Matthew C. Murphy, PE, CWI
Stonewall Structural Engineering, PLLC
2 N Front St 8th Floor
Wilmington, NC 28401
(910)444-0208

Re: Structural Observation — 4254 US-301, Dunn NC 28334

Picture 2 – A low spot in the front hallway wall

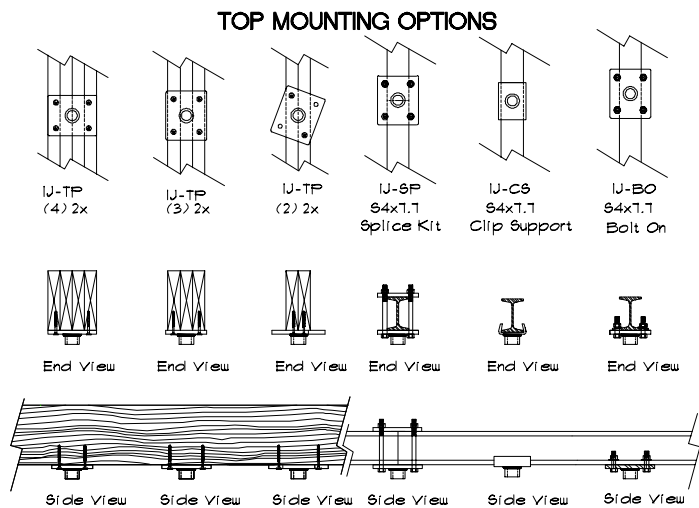
- Uneven floors were noted along the front wall of the left hallway (see *picture 2*).
 - o Measurement by laser level indicated that the low spot in the hallway was down by as much as approximately 1” relative to both the front left corner of the hallway and the back wall of the hallway.
 - Measurements from within the crawlspace found that the 4th girder span from the left was down towards the left by as much as approximately ¼”. Additionally, the 3rd girder span from the left was found to have as much as approximately ¼” sag.
 - Investigation from within the crawlspace found that a section of joists in the front joist bay approximately 18’ from the left foundation and continuing to the right by 7’ were deteriorated (see *pictures 3-4*).

- 2) To reinforce the floors under the front hallway, install a supplemental S4x7.7 dropped girder near the location of the front hallway wall. The new girder should span from the locations noted in the attached repair schematic, within the middle 1/3 of the front joist bay, over IntelliJack supports on well-compacted 18"x18"x18" gravel footings spaced no more than 6'-6" apart (*see Detail 1*).

Detail 1 – Intellijack Installation Specifications

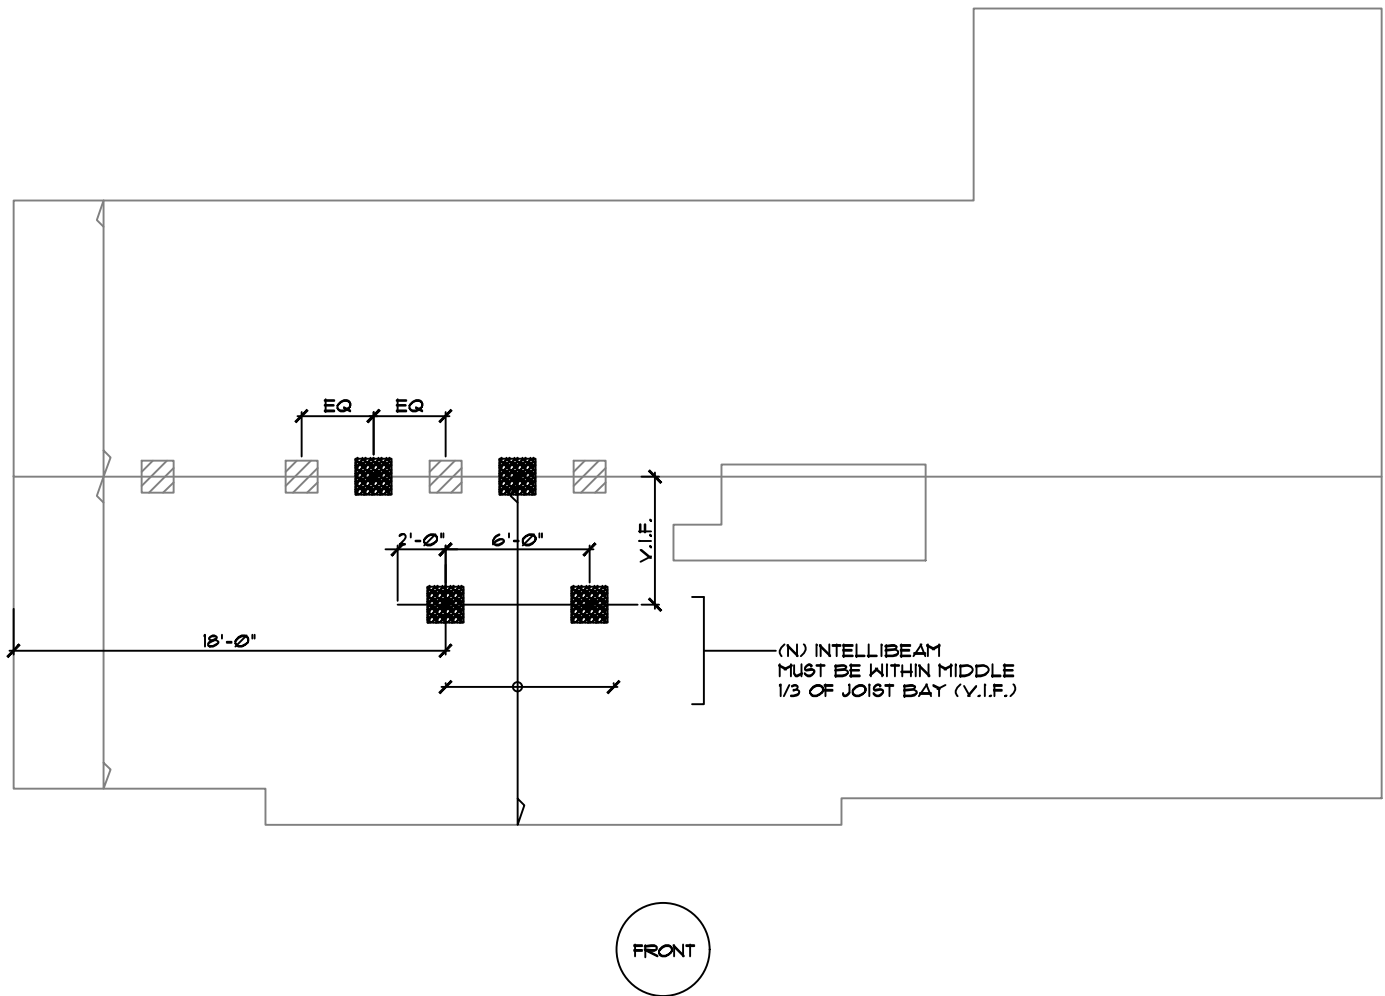
- 1) Reinforce each of the above noted dropped and/or sagging girder spans using an IntelliJack support on a well-compacted 18"x18"x18" gravel footing (*see Detail 1*). Jacks should be located within the middle 1/3 of each girder span and at the approximate locations shown in the attached repair schematic.
